# SITE PLAN

PROPERTY ADDRESS: 3690 PRONGHORN MEADOWS CIRCLE COLORADO SPRINGS, CO.

Add PCD File #  
ADR-19-007

SITE PLAN

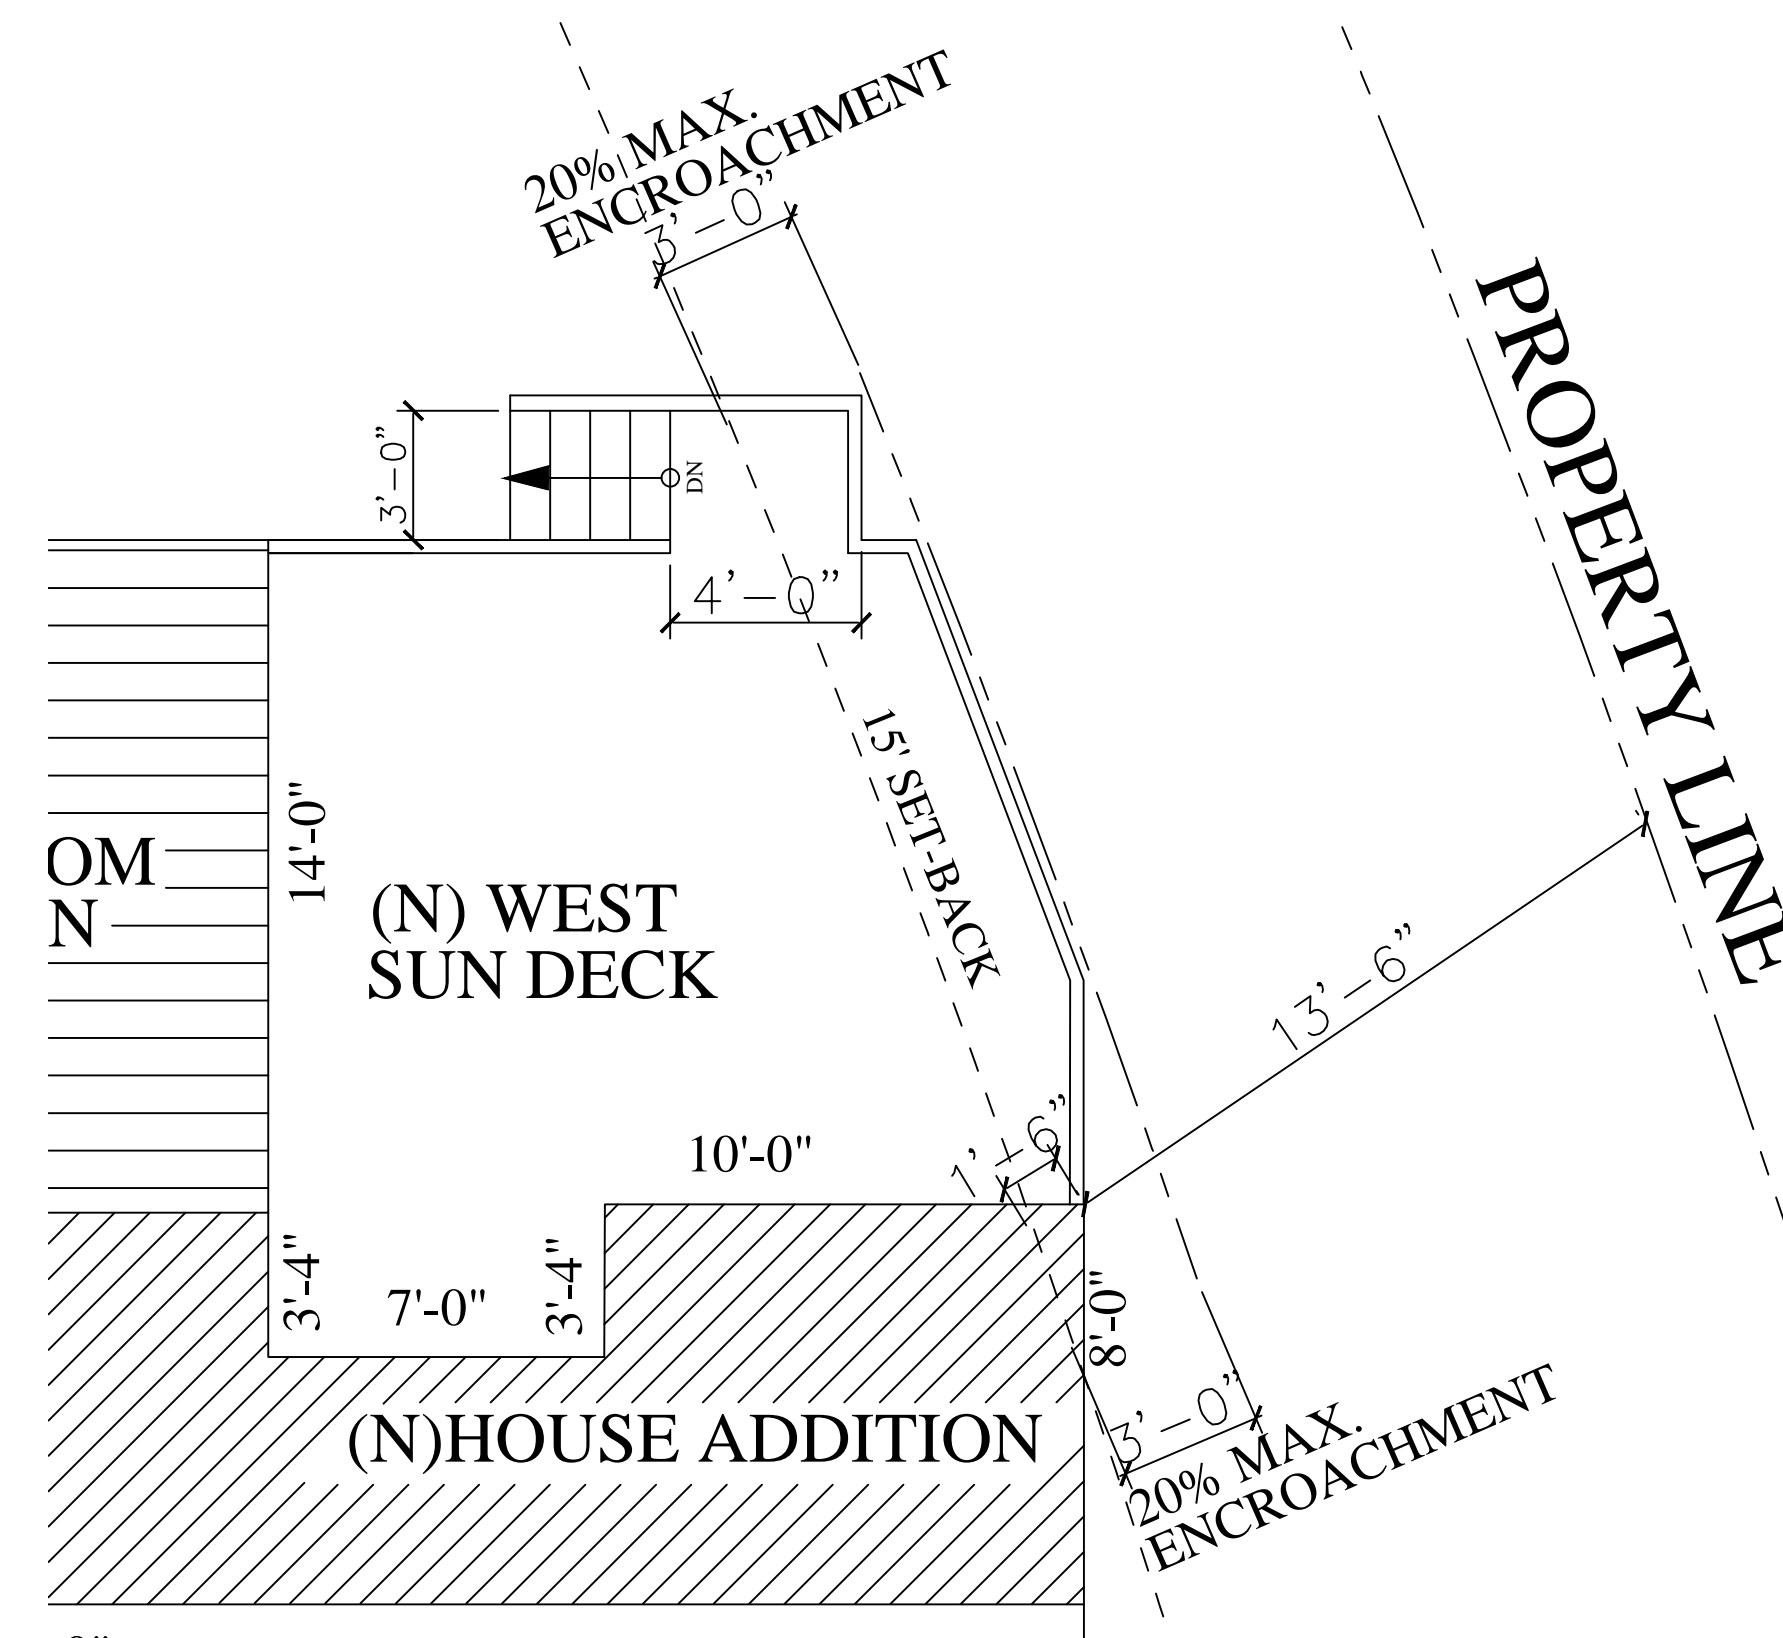
Prior to approval of administrative relief, the fence and landscape wall that extends into the public ROW (see highlighted areas above) shall be relocated within the bounds of the parcel. Please provide documentation that this has been accomplished so we can proceed with review and potential approval of the admin relief application.
